1 Joy Place (CBL #045 E049; ID#2017-128) comments

This email outlines some concerns around the plan for the building being constructed at 1 Joy Place (CBL #045 E049; ID#2017-128).

LANDSCAPE PLAN

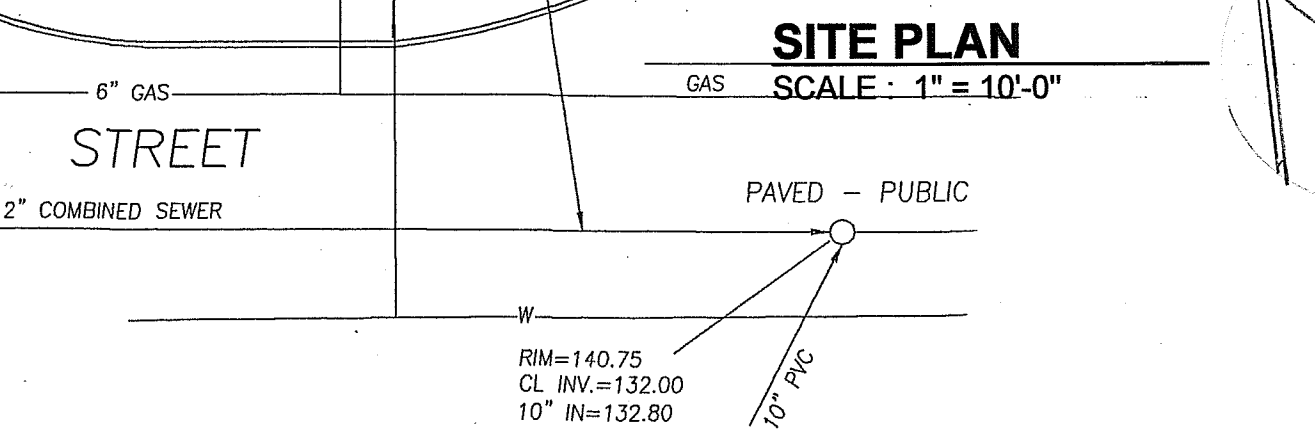
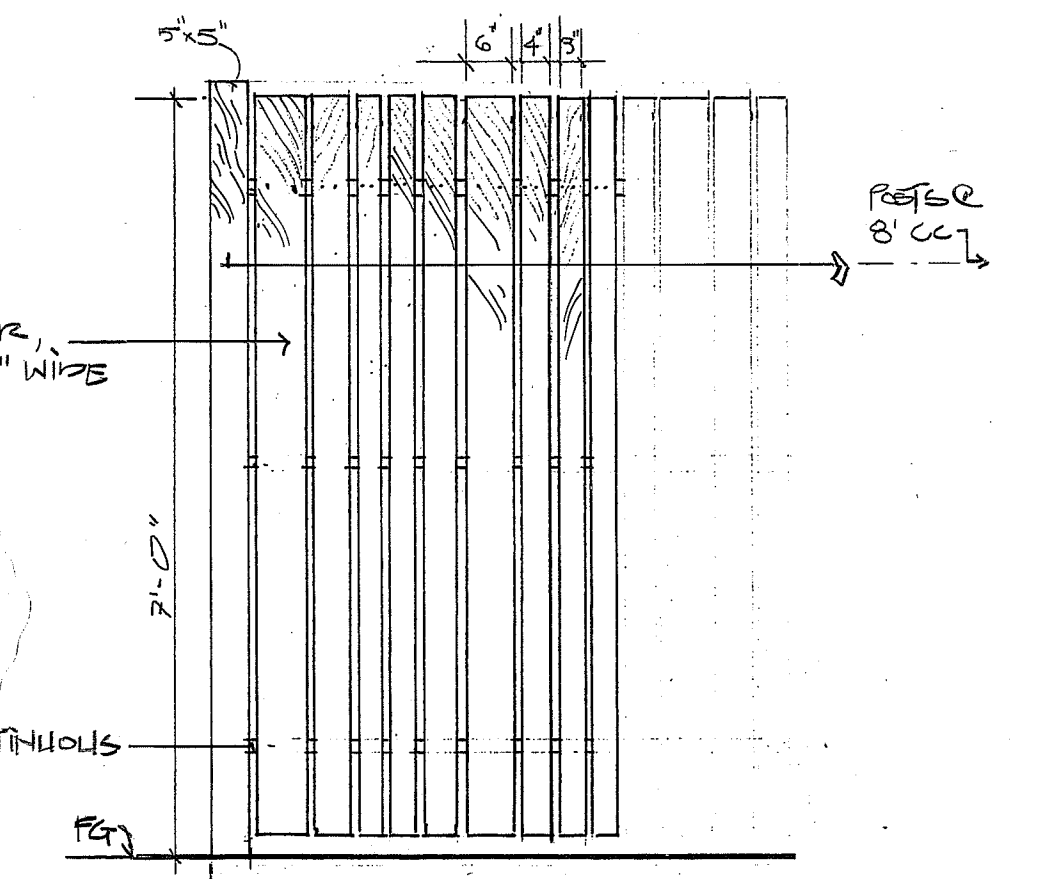
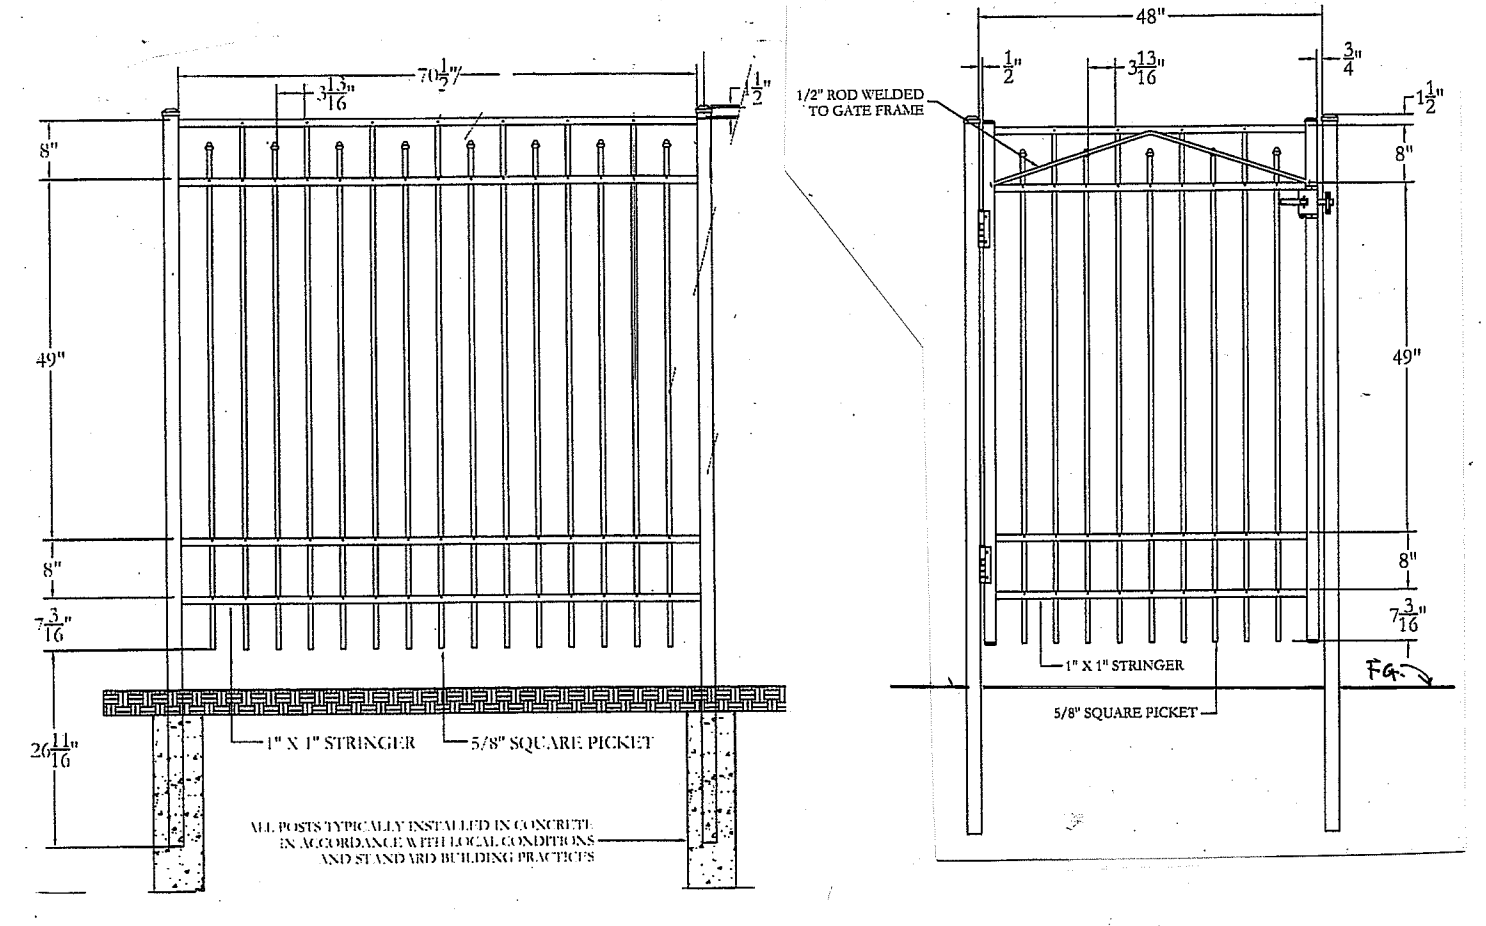
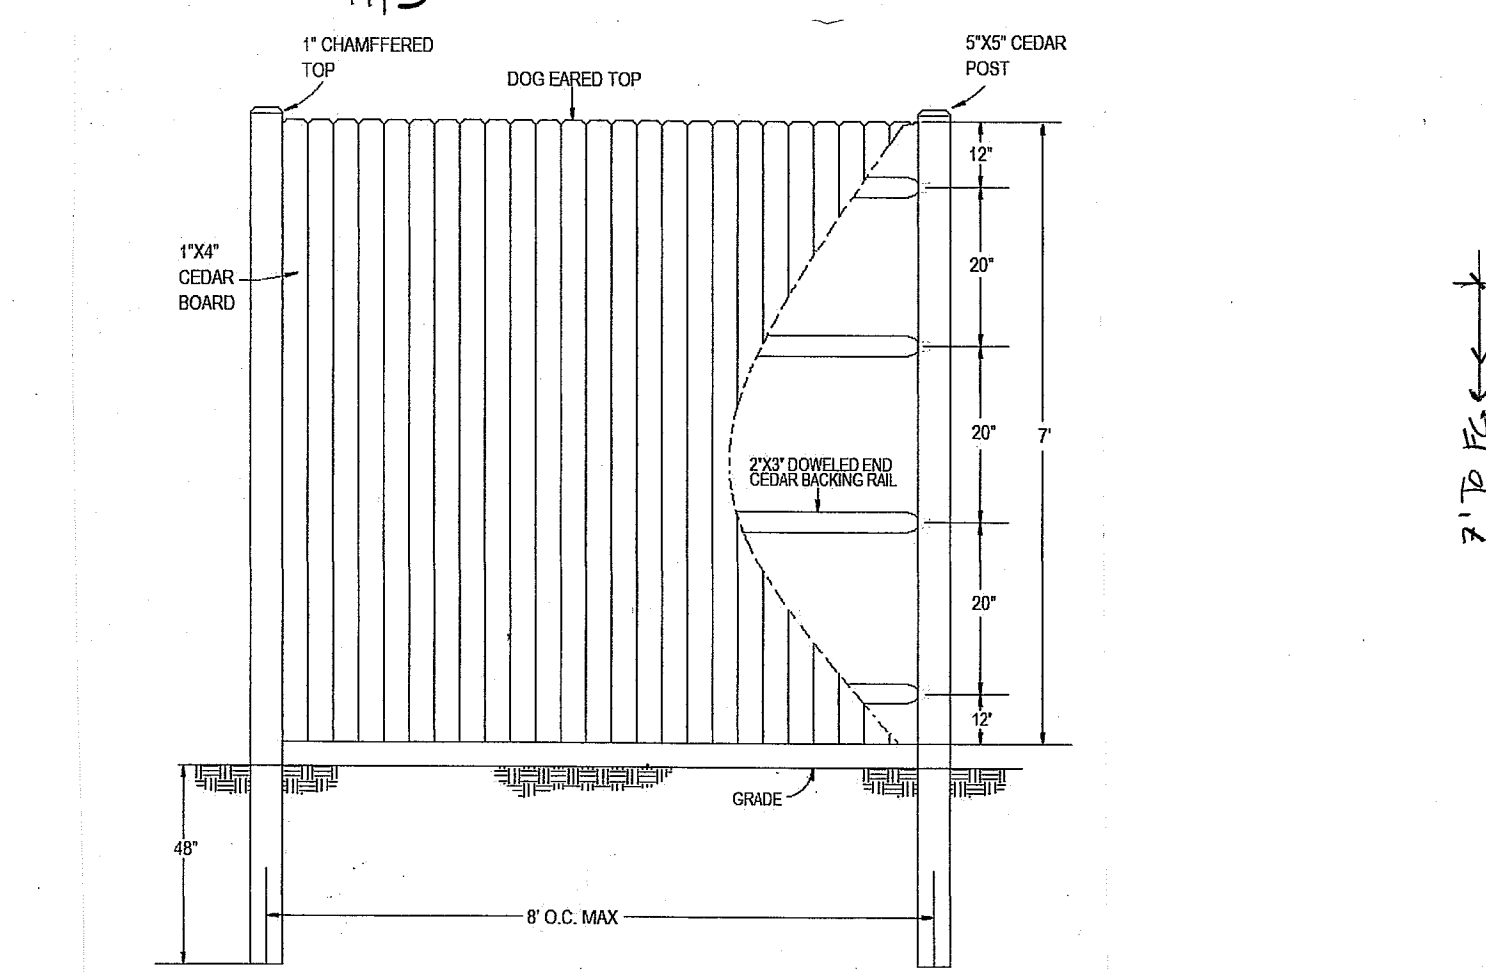
Looking at the submitted plan, it is not clear that the passageway remains sufficiently open. There wasn't a scale on the landscaping plan, so I couldn't measure it to confirm the width. I know it is tight with 1 Joy Place structure being built right up to the edge of right of way.

I also could not tell if the low-growing vinca is actually growing in a raised bed that would impinge on the travel lane.

We ask that the paving and landscaping keep the right of way a clear 12' wide, allowing for vehicles, without running into/over planting beds.

- Use a fence on our property line that is **7' or taller** and that has **no gaps between fence boards** (to maintain visual privacy between the passage between our buildings and our back yard).
- Use **solid material (wood) for fence gate** material, also for privacy.
- **Relocate gate 3-6 feet from the corner where it is located** on the plan (existing plantings on our property are in the way if it stays the corner location and would obstruct passage)
- Confirm that our deeded right of way is a clear **12' wide** and allows for vehicle passage.

We have shared these concerns with Todd Alexander, and he has said that he'll make the needed changes. I am writing to the planning board so the comments are on record and the issues are not lost in the planning process.
